**WEST SUSSEX COUNTY COUNCIL
STRATEGIC PLANNING CONSULTATION**

SUBJECT: LU/234/16/RES - Application for reserved matters relating to access, appearance, landscaping, layout and scale of the previously approved LU/63/11/. This application affects a Public Right of Way.

LOCATION: Fitzalan Link Road, Worthing Rd (A259), East Street, Littlehampton, West Sussex.

This is the fourth WSCC highways and transport response to the application seeking approval of reserved matters. Comments made below follow consideration of additional information provided in email from the applicant (Laura Graham of Persimmon Homes to Hilary Kernohan, Clare Potts and Tim Townsend) dated 30th November 2016. The text below should also be read alongside previous WSCC highways responses dated 21st September, 21st October and 21st November 2016.

rev.
P5

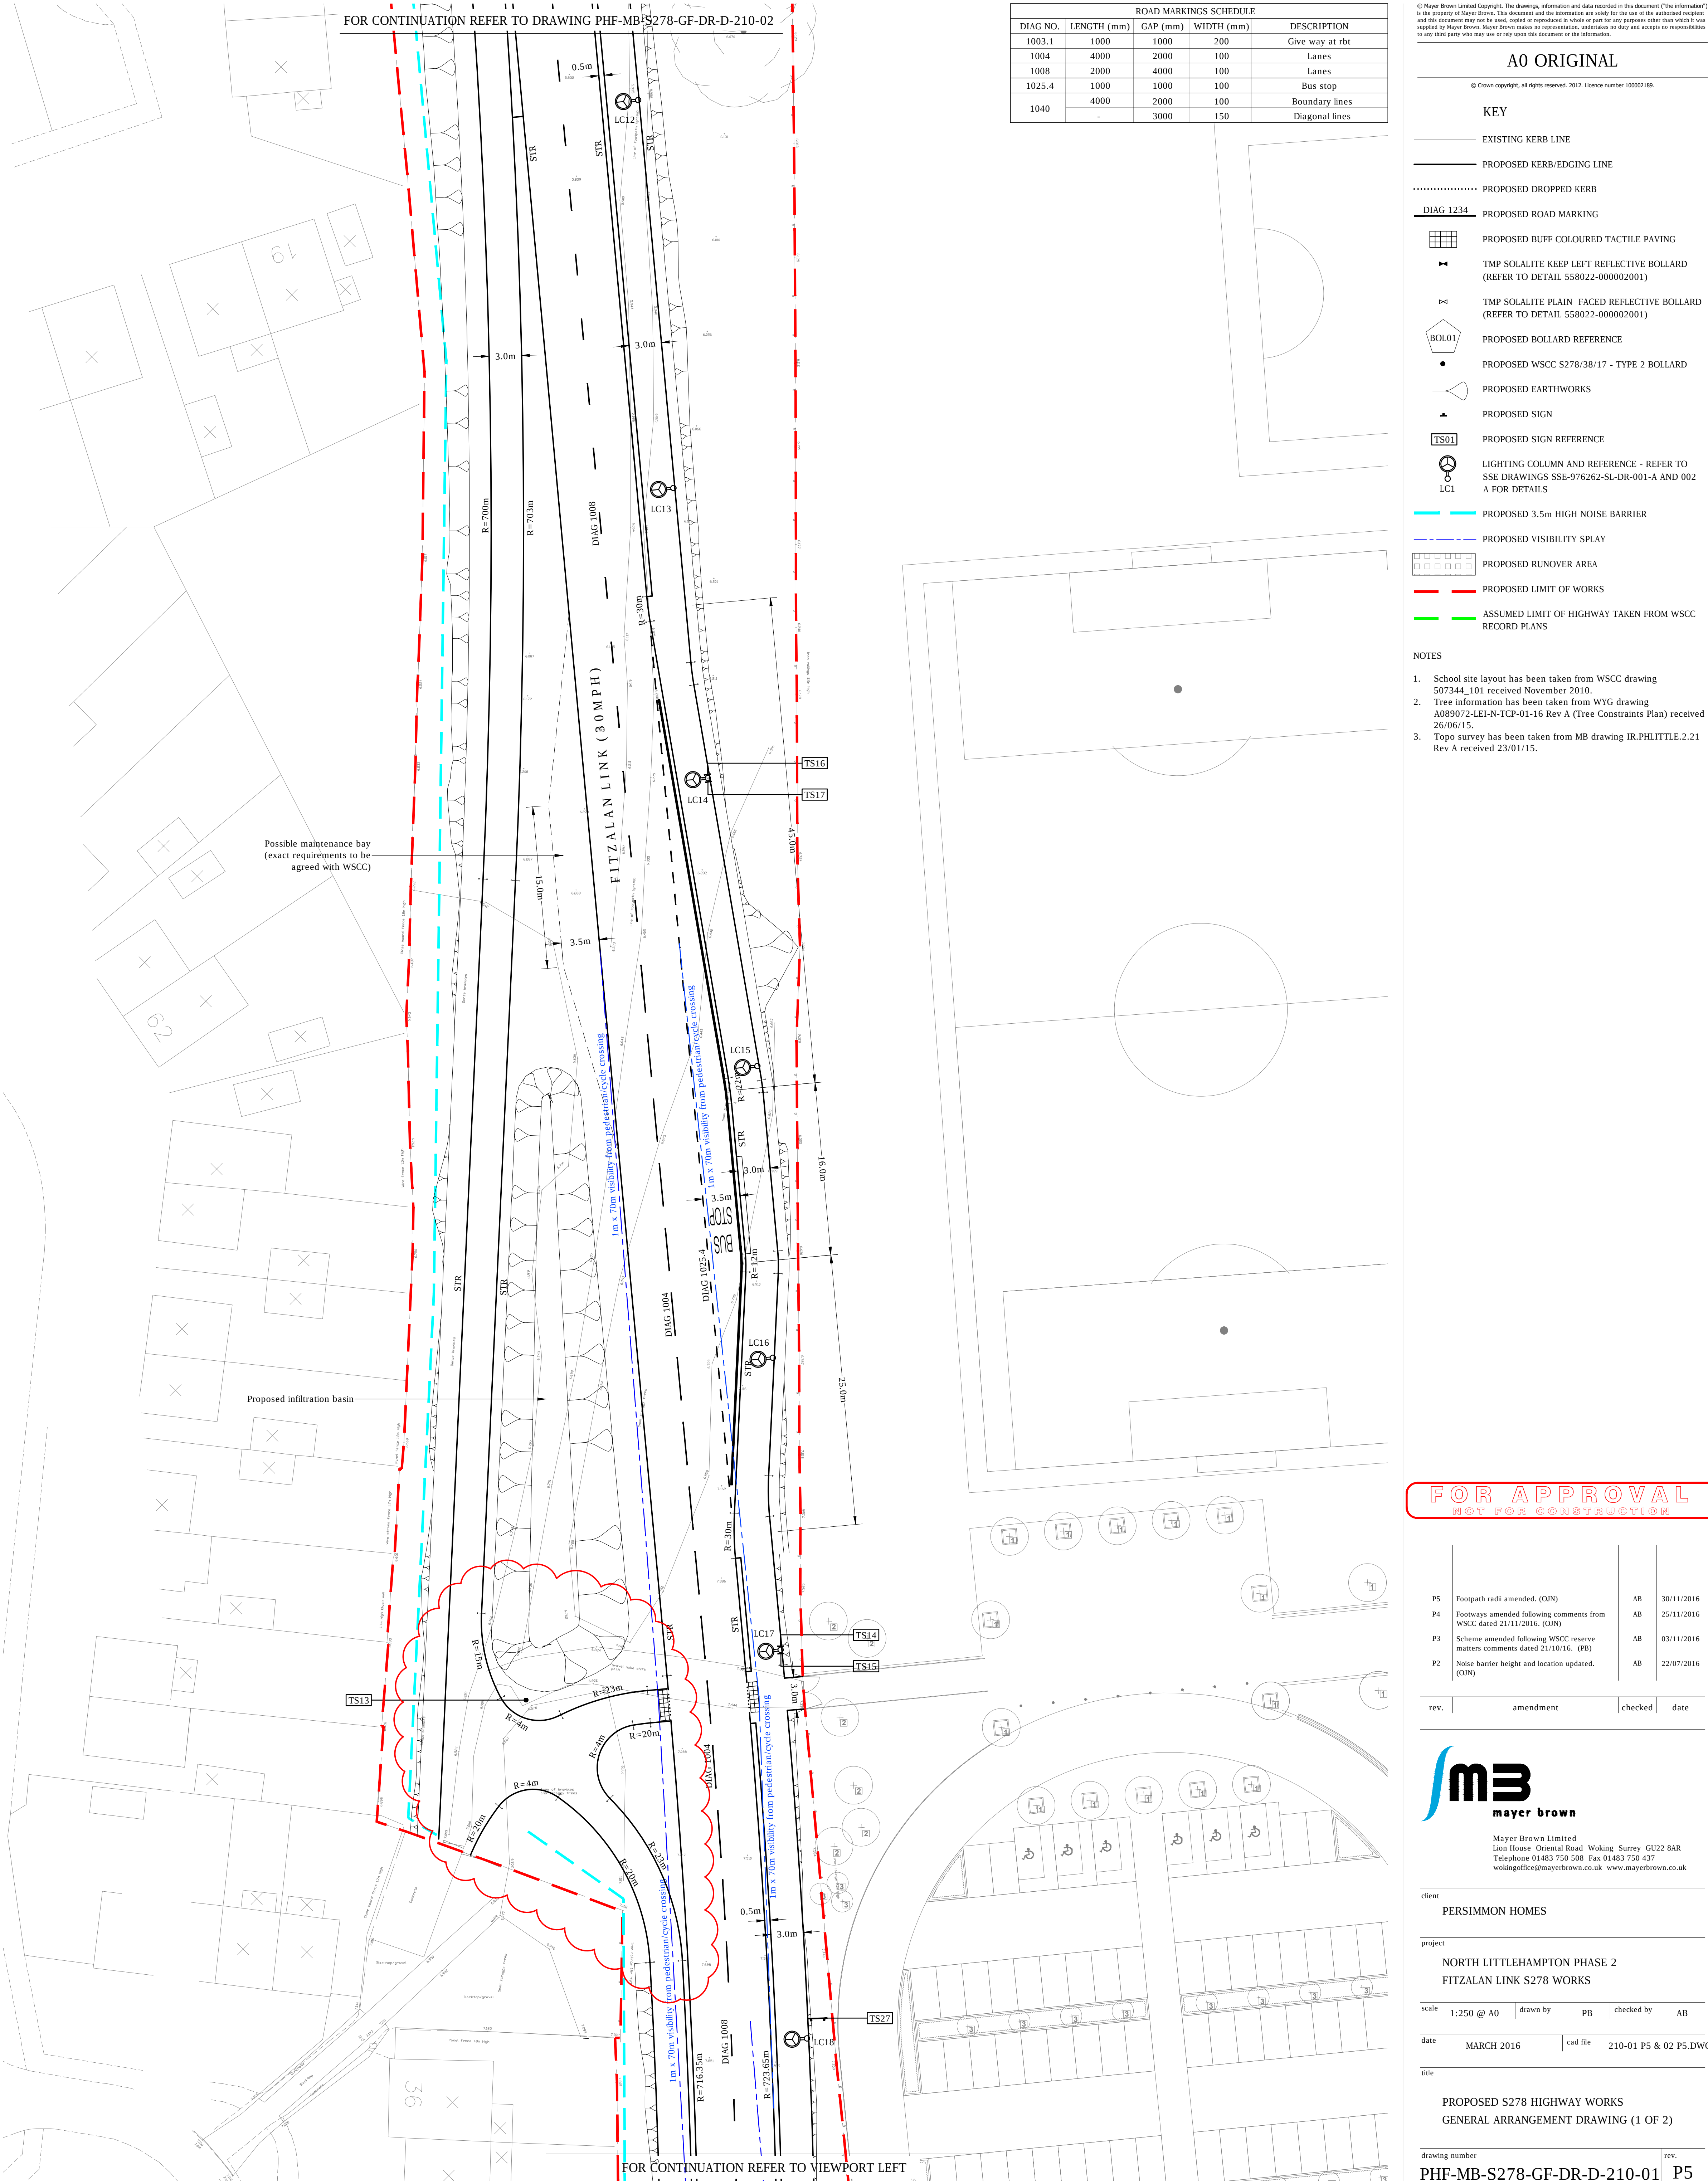
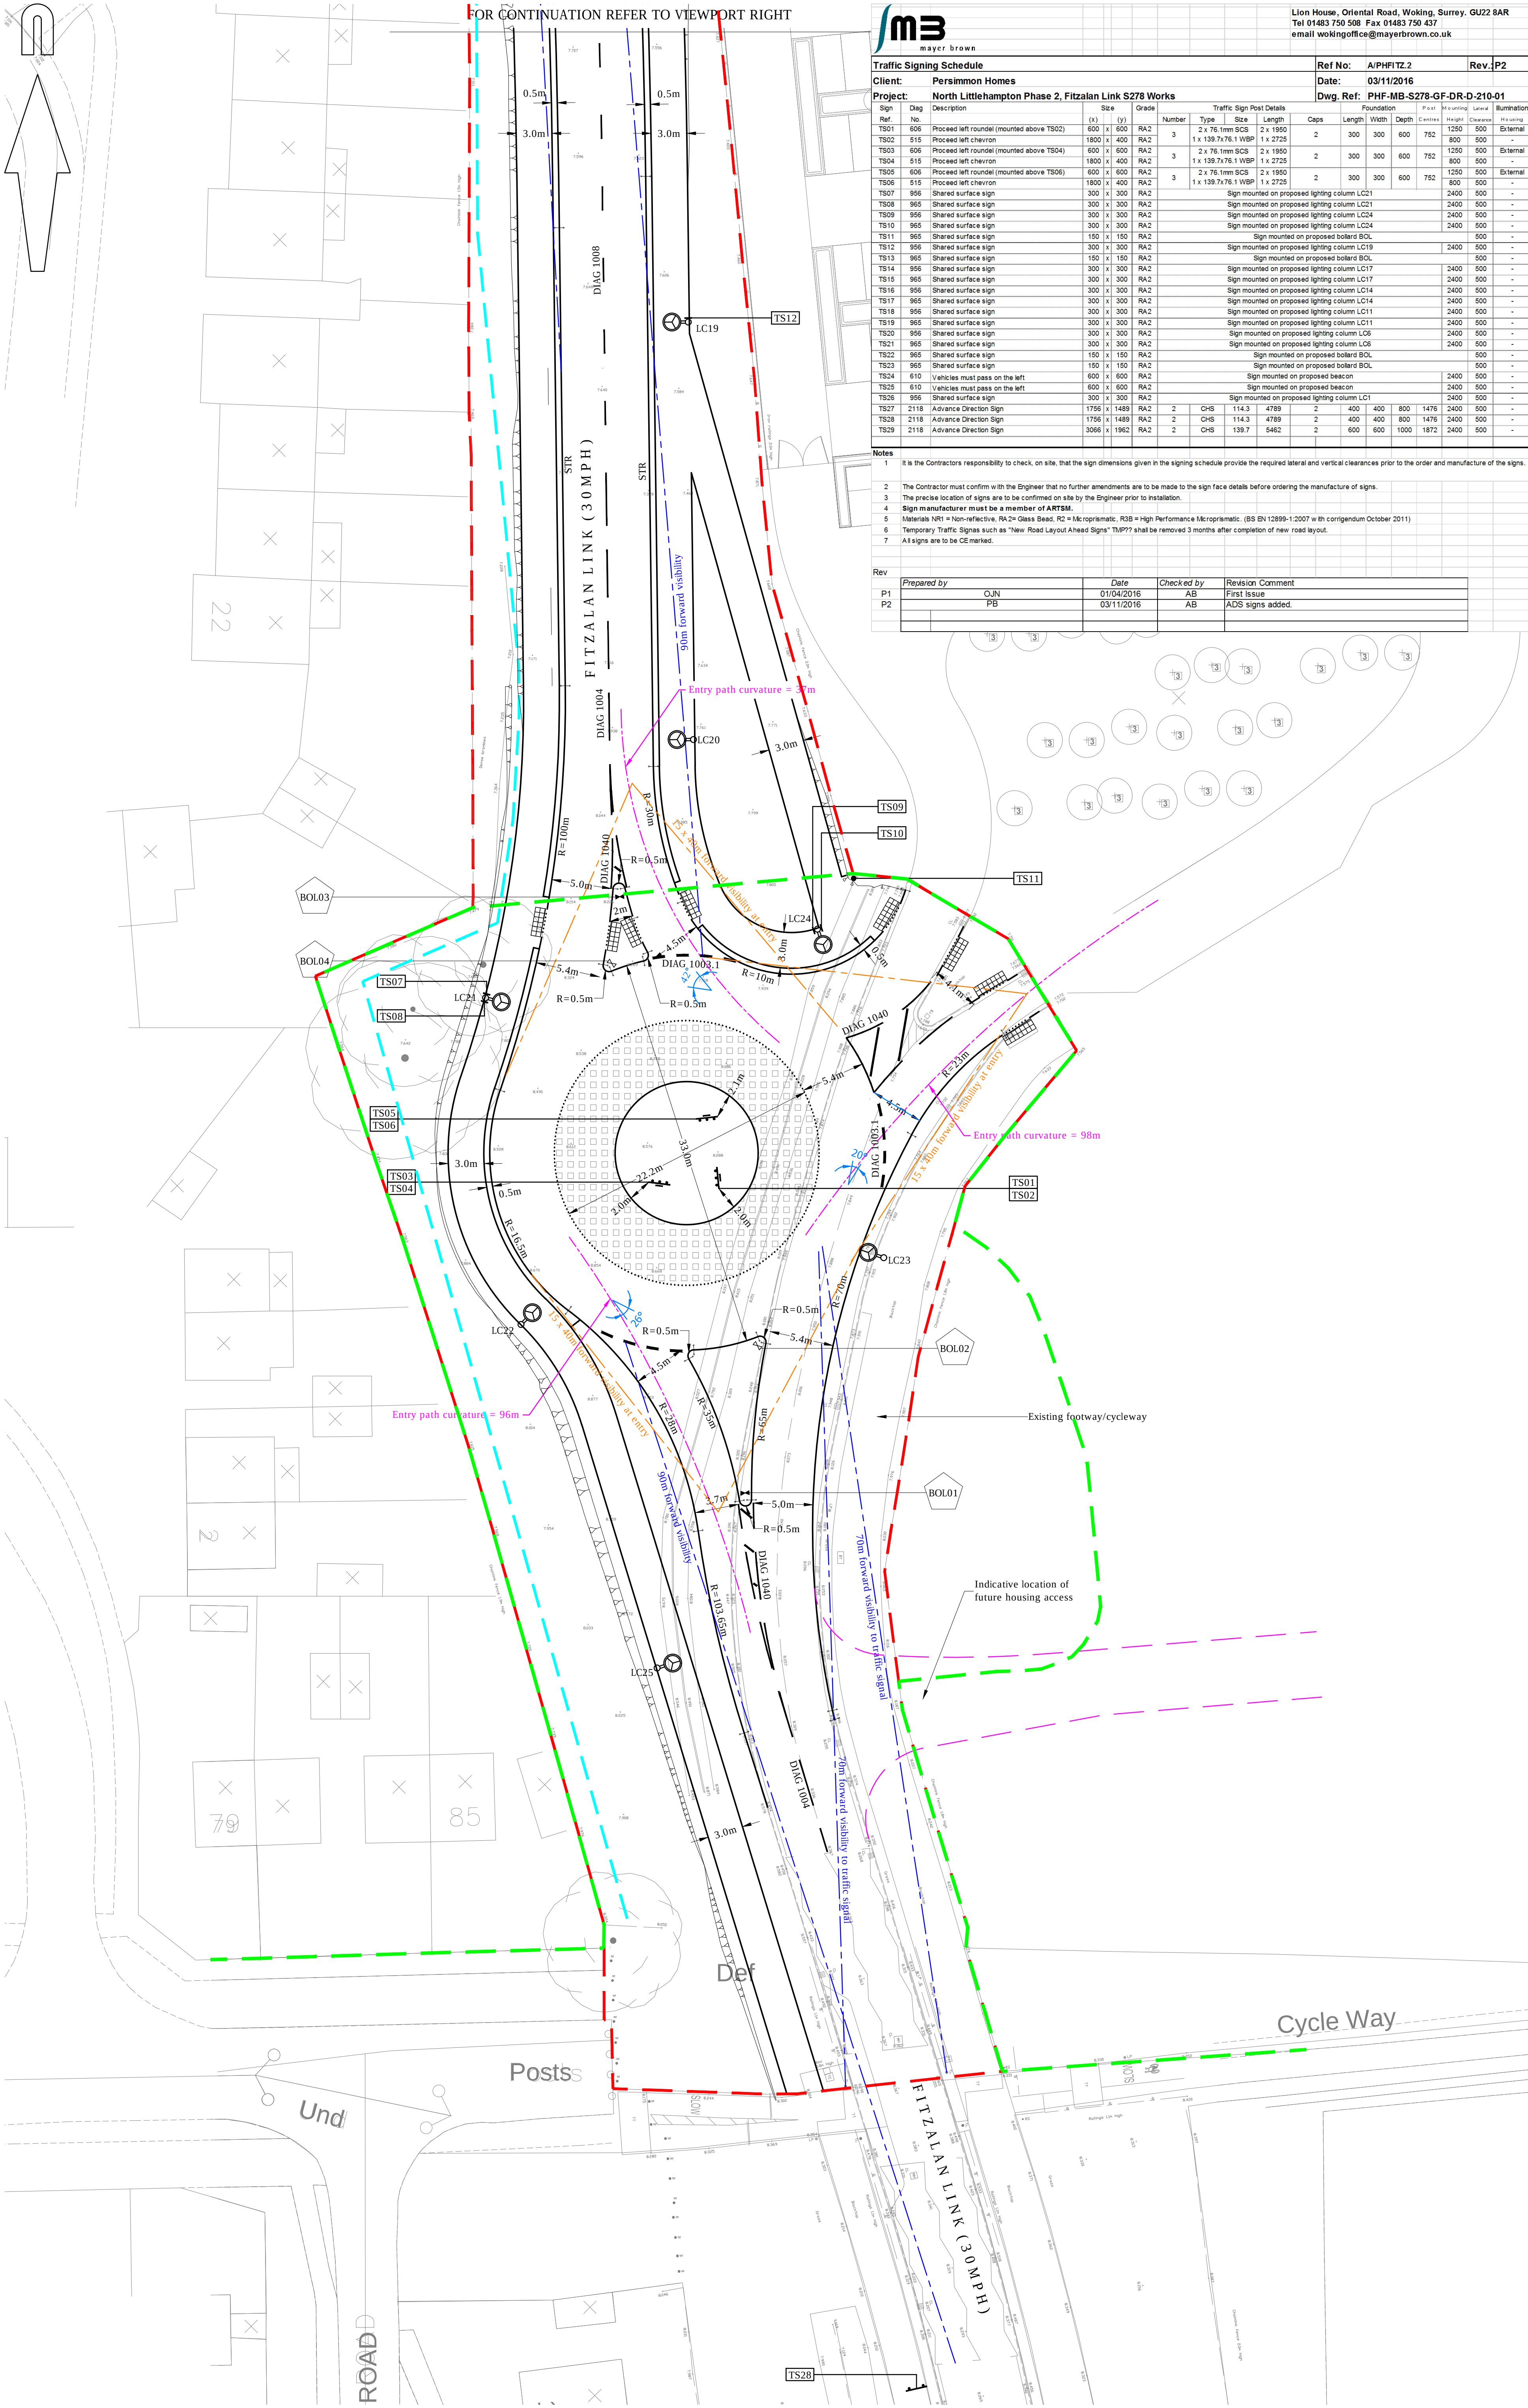
2. Bus layby south of Academy RBT – WSCC drawings for the section of road south of the Academy entrance do not appear to show the bus layby as suggested by the applicant. As such, this matter is not concluded and a further response is required from the applicant on the subject of a northbound bus layby. **Further information and alterations required.**

The approved WSCC drawings do not include a bus layby. As such, one is still required for northbound traffic to complement the one for southbound traffic. Please show.

3. Shared footpath/cycleways alongside both sides of the access road – On the western side at the point the PRow joins the scheme, the alignment is very convoluted and may not meet appropriate design standards. Please amend and remove bends etc. This also applies to the 'kink' on the eastern side of the road found further north. Also, because of the increased speed limit along the majority of the road, it is recommended that the footpath/cycleways be set-back from the edge of the carriageway by a minimum of 1.5m wherever possible. Also because of the speed limit, a signal controlled crossing should be provided in this location (Toucan). Any design should be Safety Audited before planning consent is issued. **Please provide amendments, Road Safety Audit and Designer's Response.**

Don't accept. LTN1/12 (cycle infrastructure note) says this:

- Edge of ≤40mph carriageway: add 500mm
- Edge of >40mph carriageway: add 500mm (absolute minimum)
- Edge of >40mph carriageway: add 1500mm (desirable minimum)

Clearly, if there is room at any particular point on a route then desirable minimum should be provided. As the applicant has not demonstrated that a lower speed limit is achievable, the Highway Authority still considers these features are required to mitigate the impact of higher traffic speeds on VRUs.

With regard to the alignment of the section of shared footpath/cycleway adjacent to the PRow on the western side of the road, the applicant has not provided an adequate alignment. LTN2/08 (cycle infrastructure design) has minimum design radii of 25m for commuter routes and 15m for local access routes. The route running parallel to the new road should be designed as a commuter route, and links off it should be designed as local access routes. Forward visibility requirements are also 25m and 15m respectively. Please show on an amended plan.

4. Refuge adjacent to Highdown Drive – Applicant should demonstrate that adequate kerb-to-kerb width for vehicles is provided either side of the proposed pedestrian/cycle refuge and that the refuge itself is wide enough for pedestrian and cycle usage. The full WSCC specification for refuges can be found on the WSCC website. **Further information and alterations required.**

The lanes must have minimum kerb-to-kerb widths of 3.5m each side of the refuge or similar kerbed upstand and/or feature. Please amend.

10. Maintenance access and access routes to be identified alongside road (to permit vehicles to be parked clear of the road when maintenance is taking place) – Please show.

The layby arrangement shown opposite the southbound bus stop would not be acceptable as it would be parked on and generally likely used in a detrimental way. As such, a short section of kerbing with angled/bevelled kerbing and an area of grasscrete should be provided at a suitable location for

maintenance vehicle purposes. This should be indicatively shown on a revised drawing now for planning purposes with final details being checked/agreed at the S38/278 stage.

Rejected. As indicated previously, the section of Fitzalan Link promoted by the Developer incorporates the southbound bus lay-by as previously agreed within the outline consented scheme. For some reason, it would appear that the northbound bus lay-by was never constructed as part of the Academy access works promoted by WSCC. This is a matter for WSCC to address on the section of the Fitzalan Link that they have delivered. It is not a matter for the RMA prepared by the Developer.

Accepted. The full extent of the land required to implement the outline consented scheme has not been made available. As a result, the alignment of the shared footway/cycleway has been altered from that indicated at Outline Consent stage. The geometry of the facility on the western side has been revised to provide a more suitable design and continuity of the PROW within the constraints of the site limits. The proposed PROW ties into the existing PROW route at the red line. Please refer to amended drawings PHF-MB-S278-GF-DR-D-210-01 Rev P5 and PHF-MB-S278-GF-DR-D-PROW-01 Rev P3.

The geometry of the eastern facility has been amended to provide a more suitable design as requested. Please refer to amended drawings PHF-MB-S278-GF-DR-D-210-02 Rev P5 and PHF-MB-S278-GF-DR-D-PROW-01 Rev P3.

Accepted. The design has been amended to incorporate a pedestrian refuge island as required by WSCC detail numbered S278/38/19 Rev B with 3.2m lane widths, 2.5m wide island and road markings offset from the island, as requested. Please refer to amended drawings PHF-MB-S278-GF-DR-D-210-02 Rev P5.

Accepted. The existing footway/cyclepath has been shown as retained on amended drawings PHF-MB-S278-GF-DR-D-210-01 Rev P5 and the updated landscaping plans prepared by WYG.

Noted. I'm sure this will be discussed in greater detail during the detailed technical approval stage. However, a maintenance bay has been included within the scheme, north of the Academy roundabout for maintenance vehicles. Please refer to the MB general arrangement drawing PHF-MB-S278-GF-DR-D-210-01 Rev P5.
